FORMAL OBJECTION TO PLANNING APPLICATION

Reference: 2026/62/91551/E

Site Address: Shepley Carr House, Shepley, HD8 8BR

Proposal: Erect detached Garage and detached Garden Room

Client Mr and Mrs Kernahan
Project 2669 - Shepley Carr House : Domestic Extension
Title Proposed Garage & Garden Room Elevations
Drawn BH Auth BH

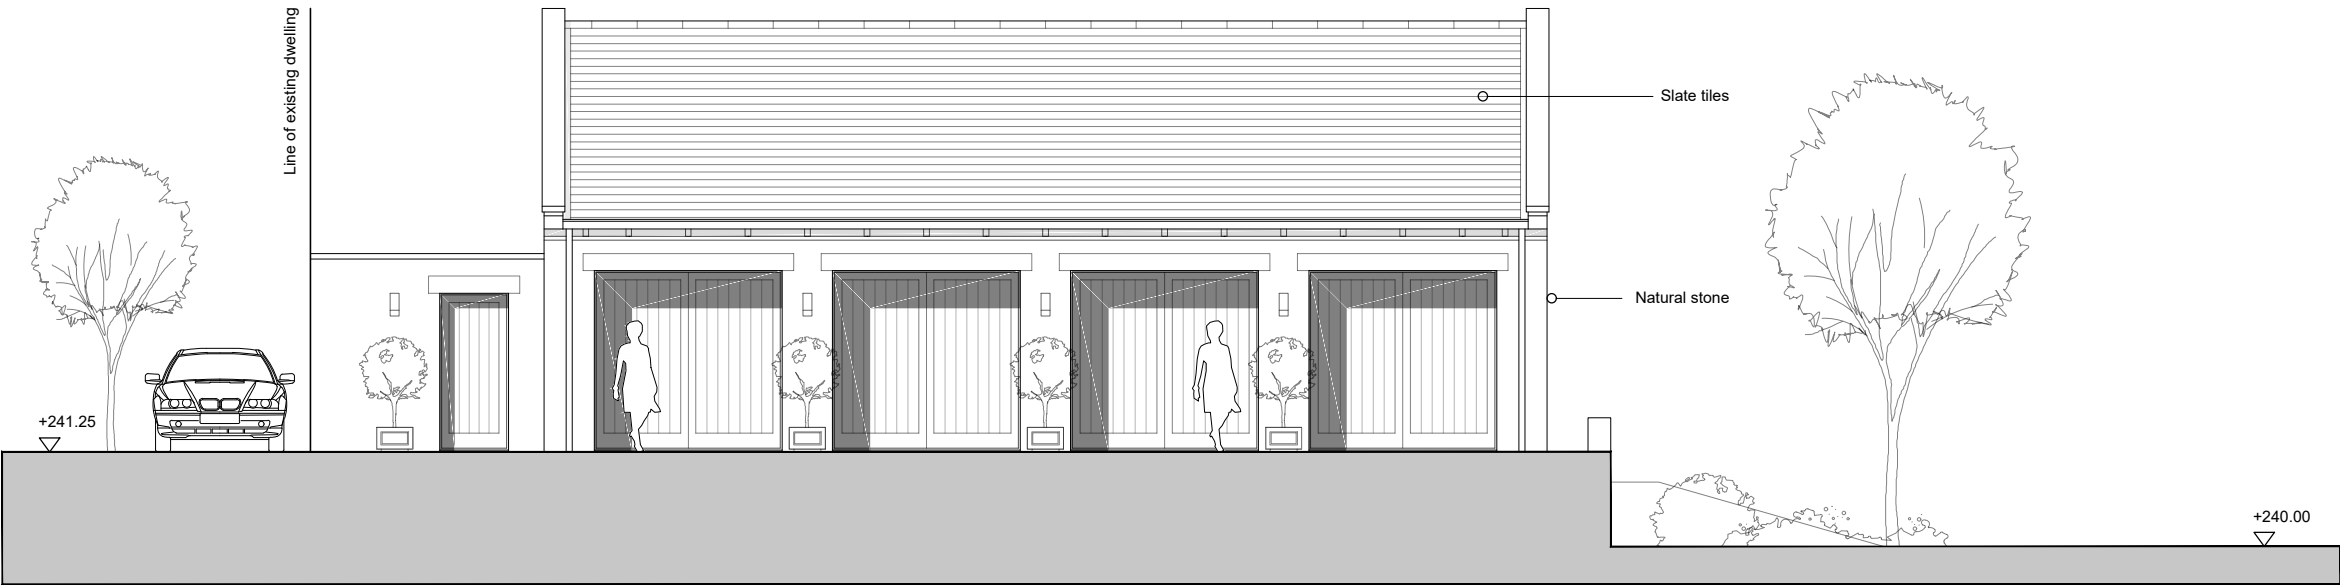
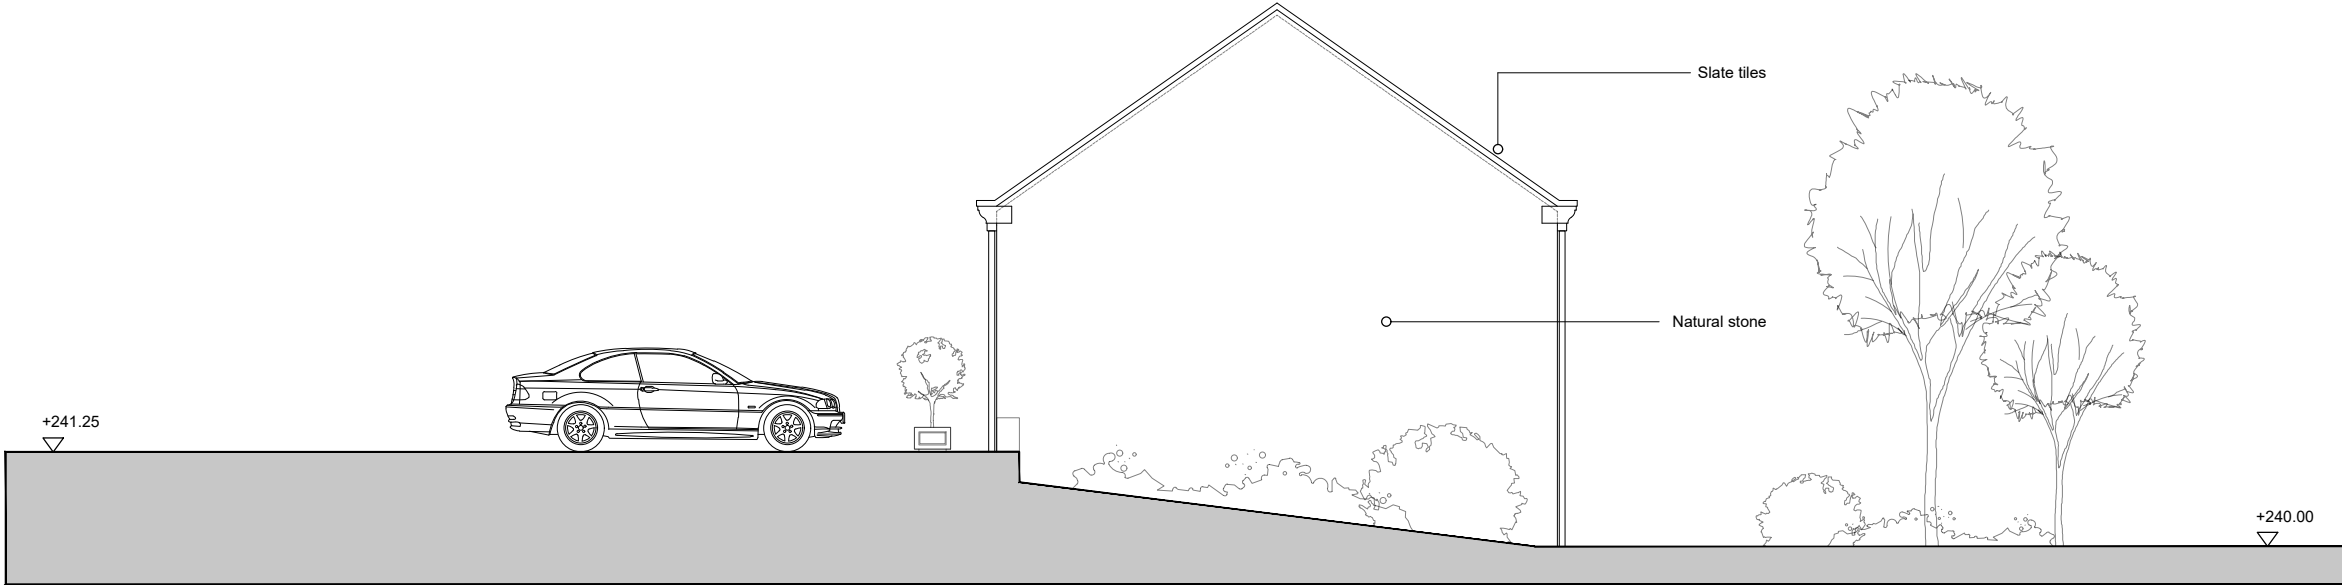
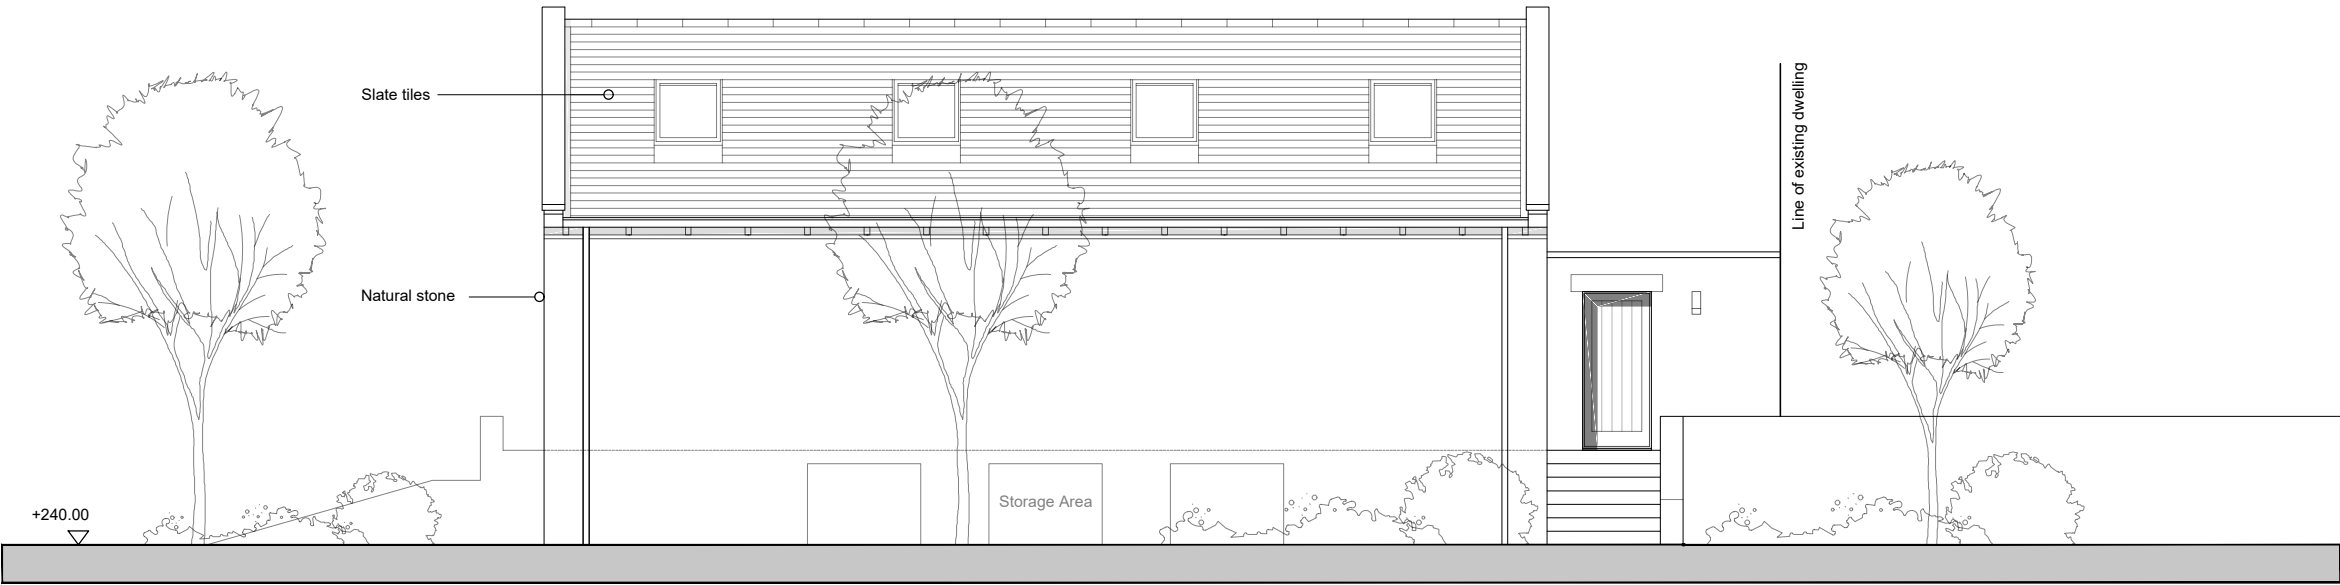
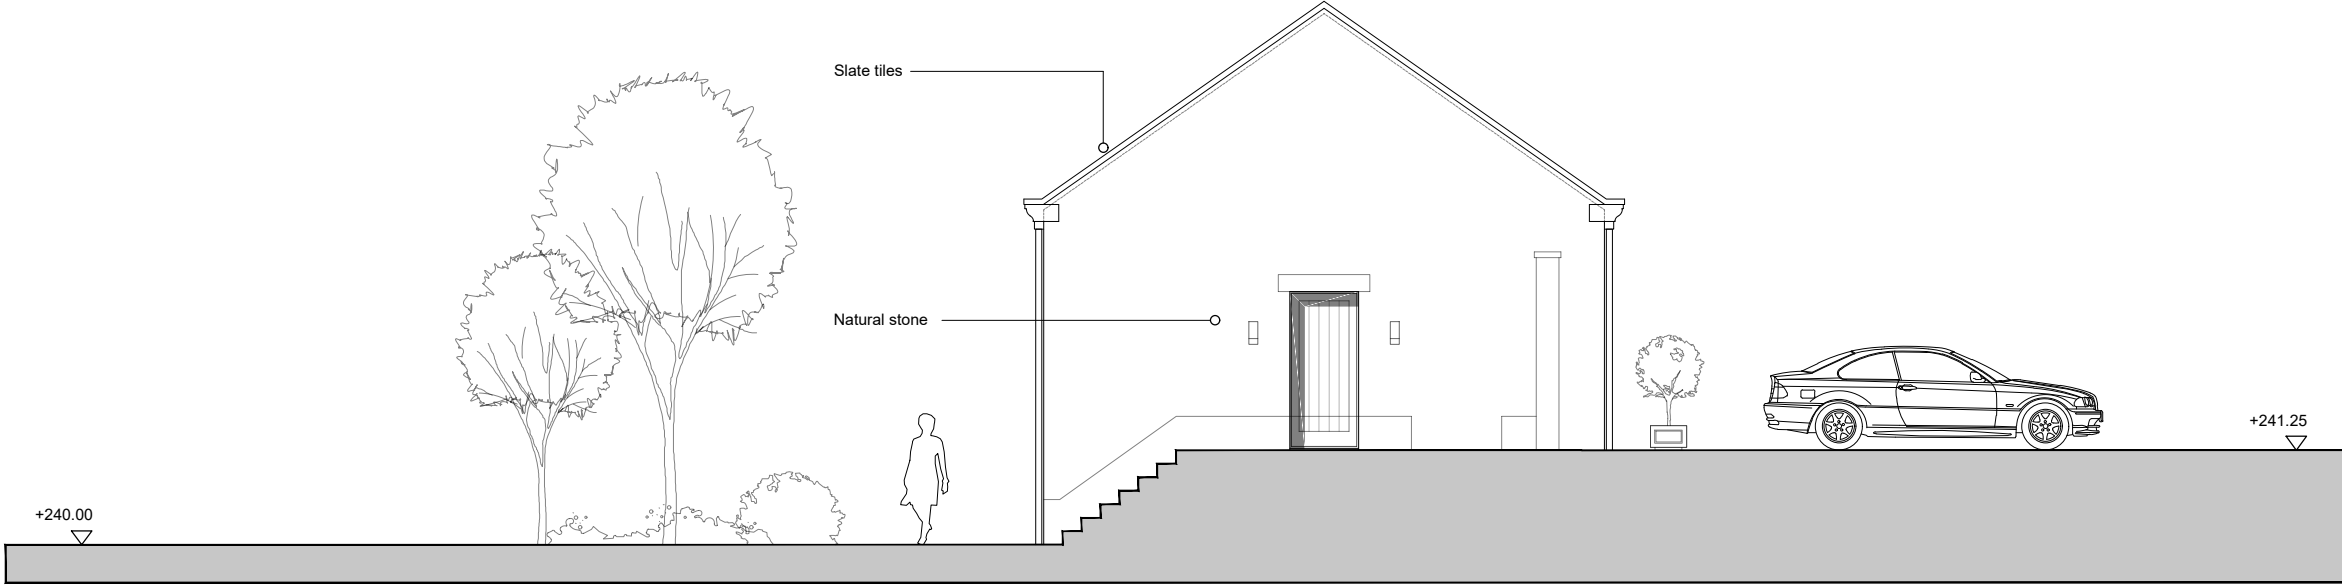
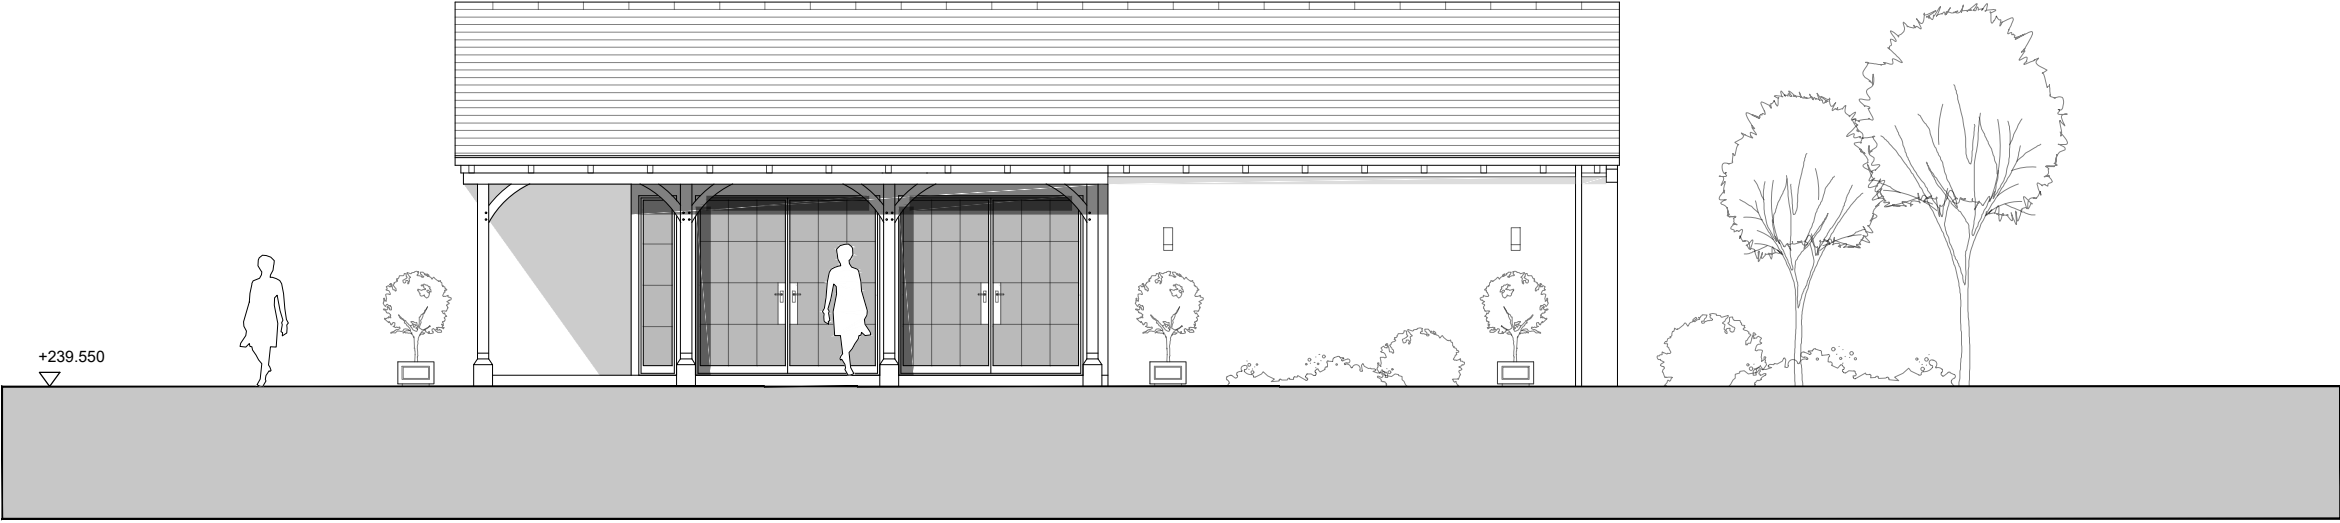
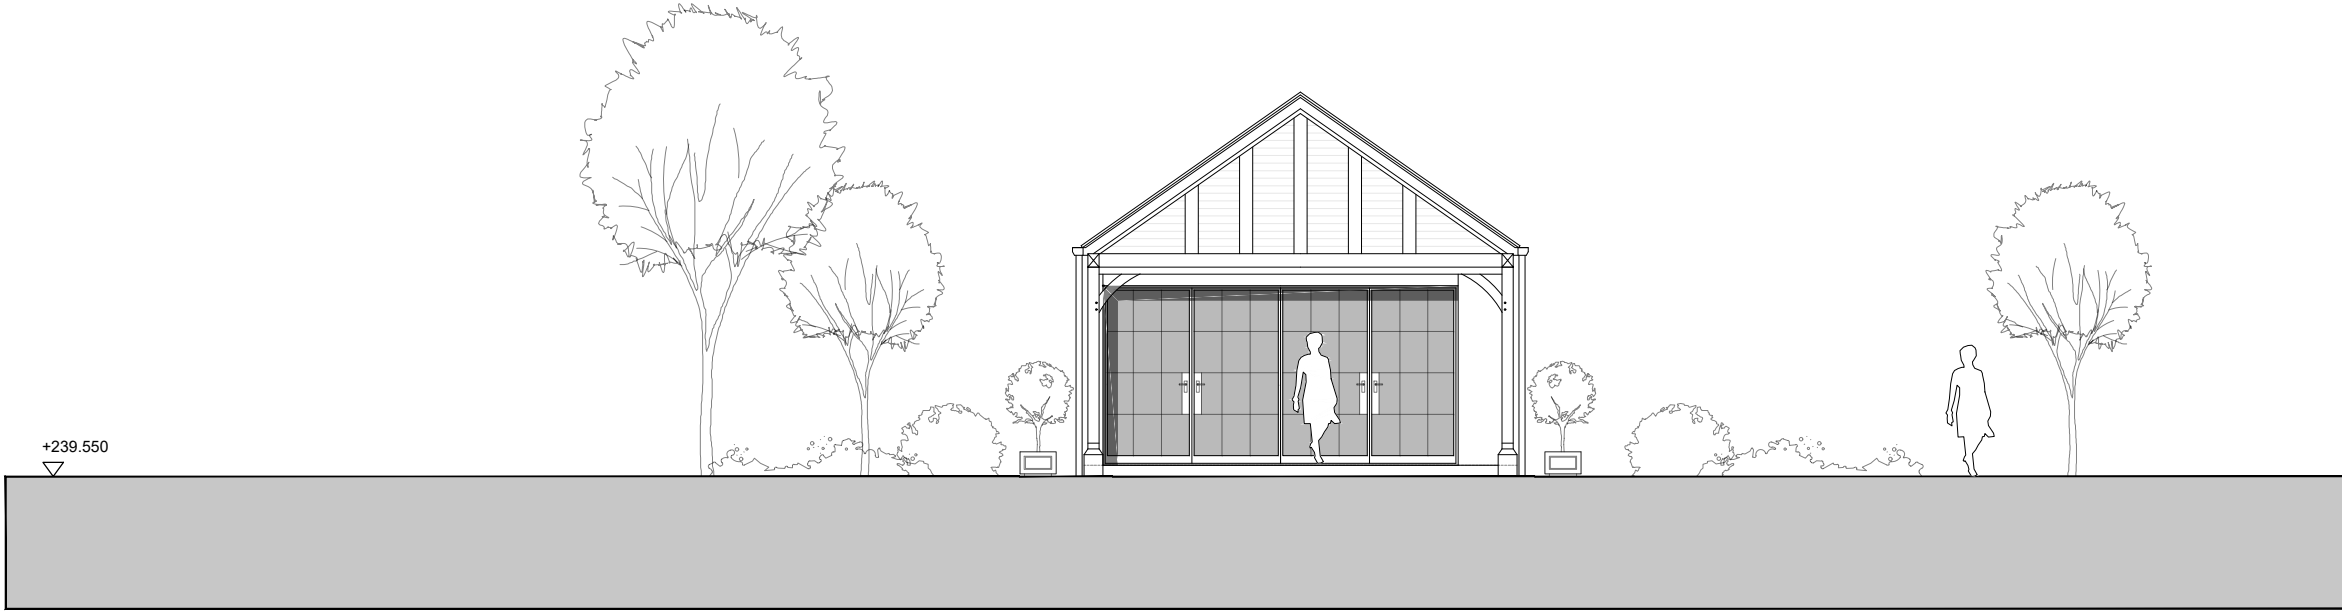
The inclusion of down-lighting within the external soffits above the proposed garage doors introduces a suburban, heavily illuminated feature that is entirely hostile to the rural setting of this Non-Designated Heritage Asset (NDHA).

- **Concealed Architectural Relationship:** The elevations completely omit to illustrate the proposed detached Garage and Garden Room/Golf Simulator in direct visual relation to the host dwelling (Shepley Carr House). The structures are drawn in total isolation. Because the house is an irreplaceable heritage asset, the applicant has a strict duty to provide contextual elevations under Policy LP35 to demonstrate how the proposal preserves its setting.

- **Omission of Ridge Heights:** The drawings completely fail to state the proposed ridge heights, eaves heights, or exact structural dimensions for either the Garage or the Garden Room. Scale analysis of site plan drawing shows that the proposed Garden Room and Golf Simulator features an elongated footprint measuring approximately **14.5 metres in length** by **4.5 metres in width**, while the Garage measures approximately **10.5 metres in length** by **5.5 metres in width**. Without clear vertical dimensional data matching these large horizontal footprints, the council cannot mathematically evaluate the level of overshadowing to neighboring plots or the visual dominance on the heritage asset. The application remains technically un-assessable.
